Address: Fourth Floor Flat, 48-49 Gloucester Square, London, W2 2TQ,

Proposal: Detailed plan, elevation and section drawings of screening for the two plant units pursuant to Condition 4 of planning permission dated 18 December 2020 (RN: 20/06754). Linked application - 21/01308/ADLBC

Drawing Title
49 Gloucester Square
Proposed AC Enclosure Details

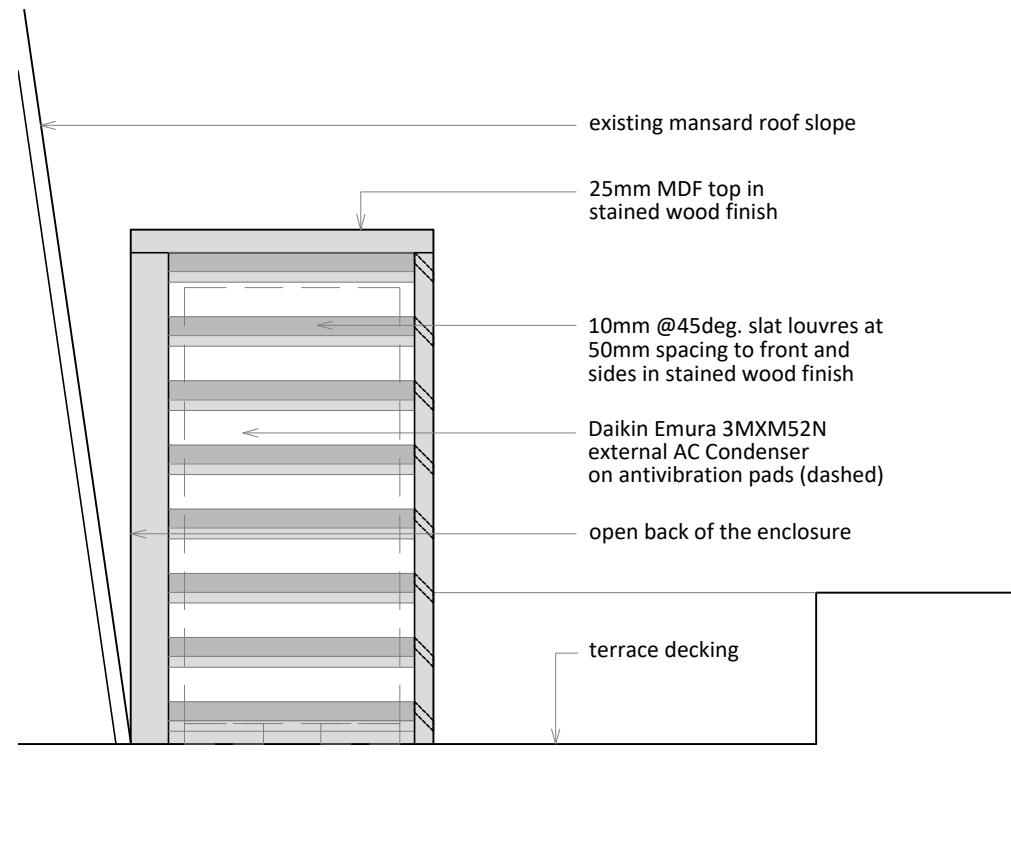
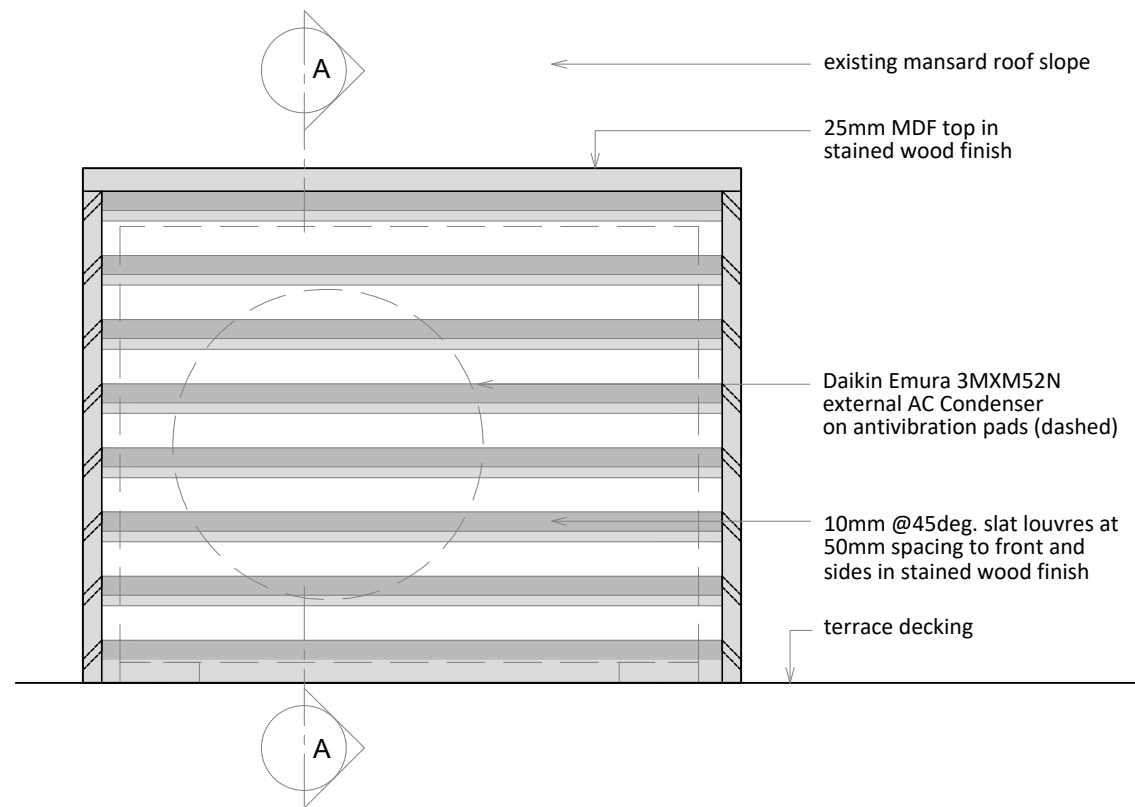
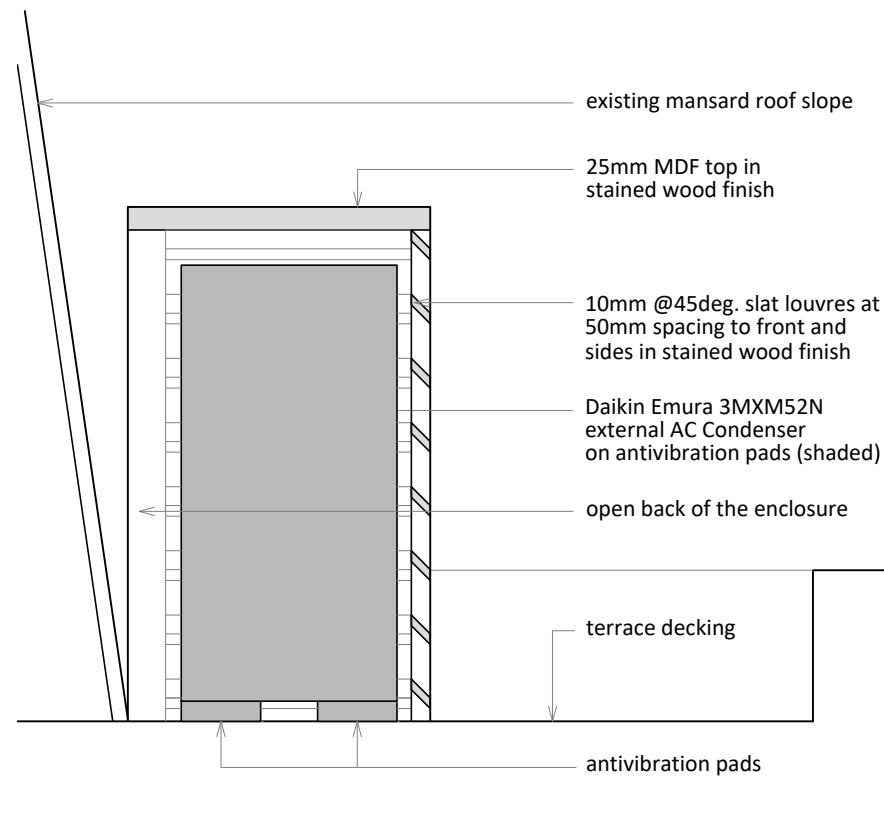
- 1 The information provided does not satisfy the requirements of condition 4 which you are seeking to discharge. For example no section drawing.
